From: Julie Grieves on behalf of Planning.Responses
Sent: 05 April 2019 09:59
To: Planning Scanning
Subject: FW: AL/129/18/OUT - Land East of Orchard Gardens, Woodgate

I am finalising my report for outline planning application AL/129/18/OUT - Land East of Orchard Gardens, Woodgate.

Drawing 5919/100 showing Right Turn Lane

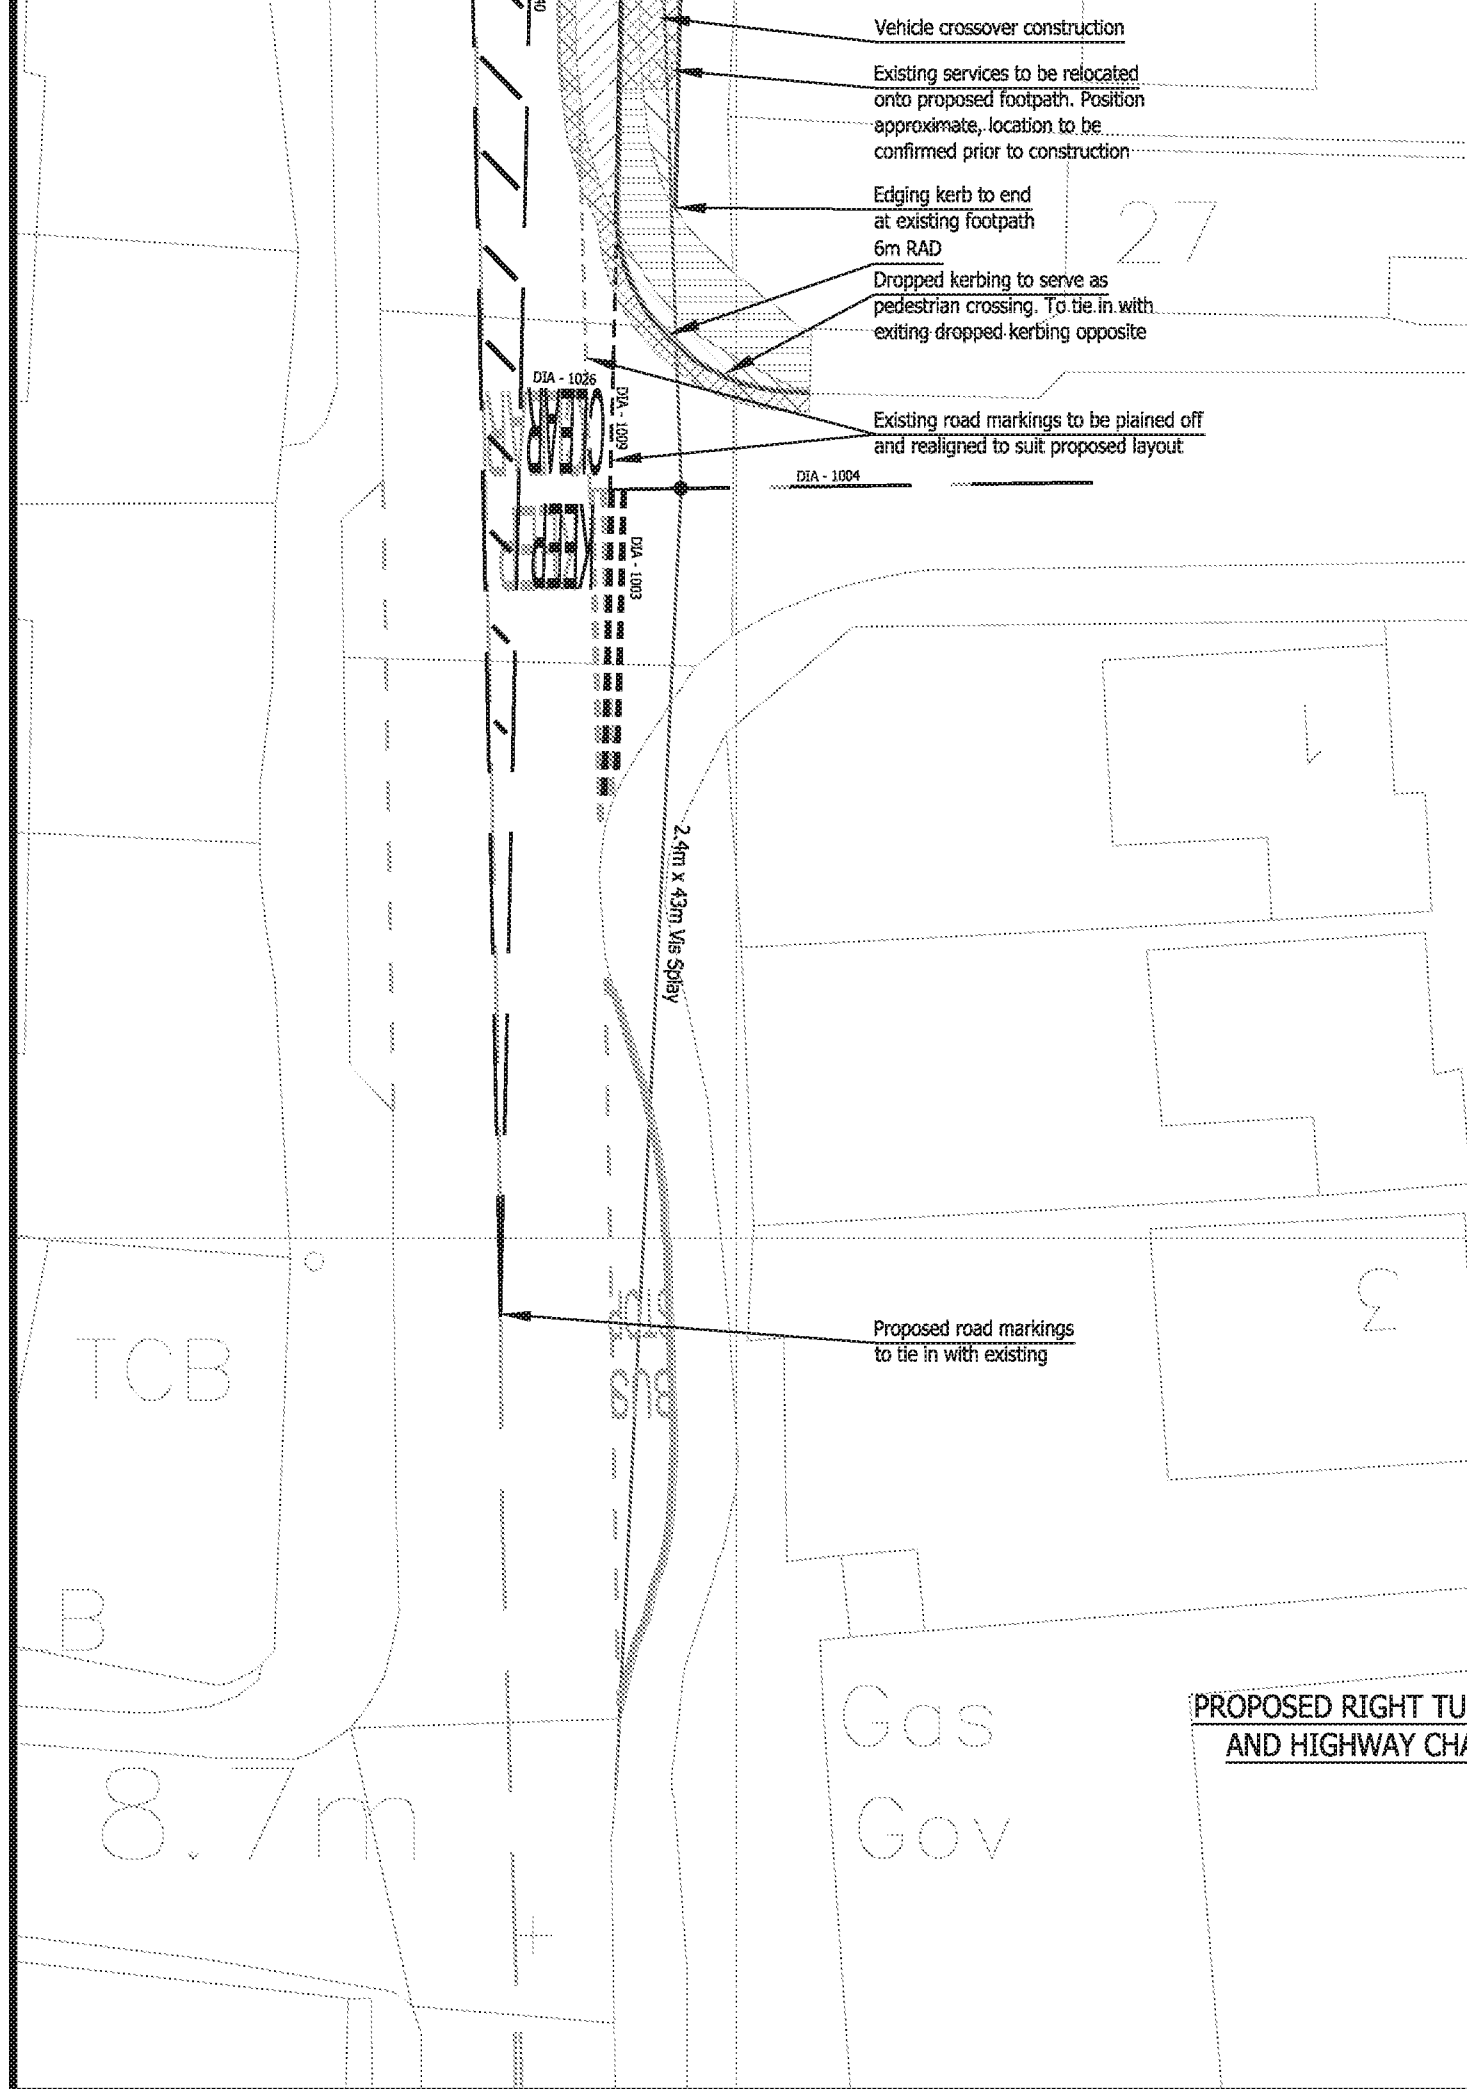
In your consultation response you say: "The 2.4 metre by 43 metre visibility splay proposed at the junction of Orchard Gardens is a departure from standards. The Local Highway Authority would be satisfied with a 3.0 metre 'X' distance by 43 metre visibility splay. This has been agreed with the applicant. The Local Highway Authority has requested that the plan is modified to show the 3.0 metre by 43 metre 'X' distance".

Has the applicant submitted the modified plan showing the 3.0 metre by 43 metre 'X' distance?

If not, are you happy for the modified plan showing the 3.0 metre by 43 metre 'X' distance to be made the subject of a condition?

The 'X' distance was agreed with ourselves when the previous application was submitted. I am therefore happy with the plan submitted with the said visibility splays.
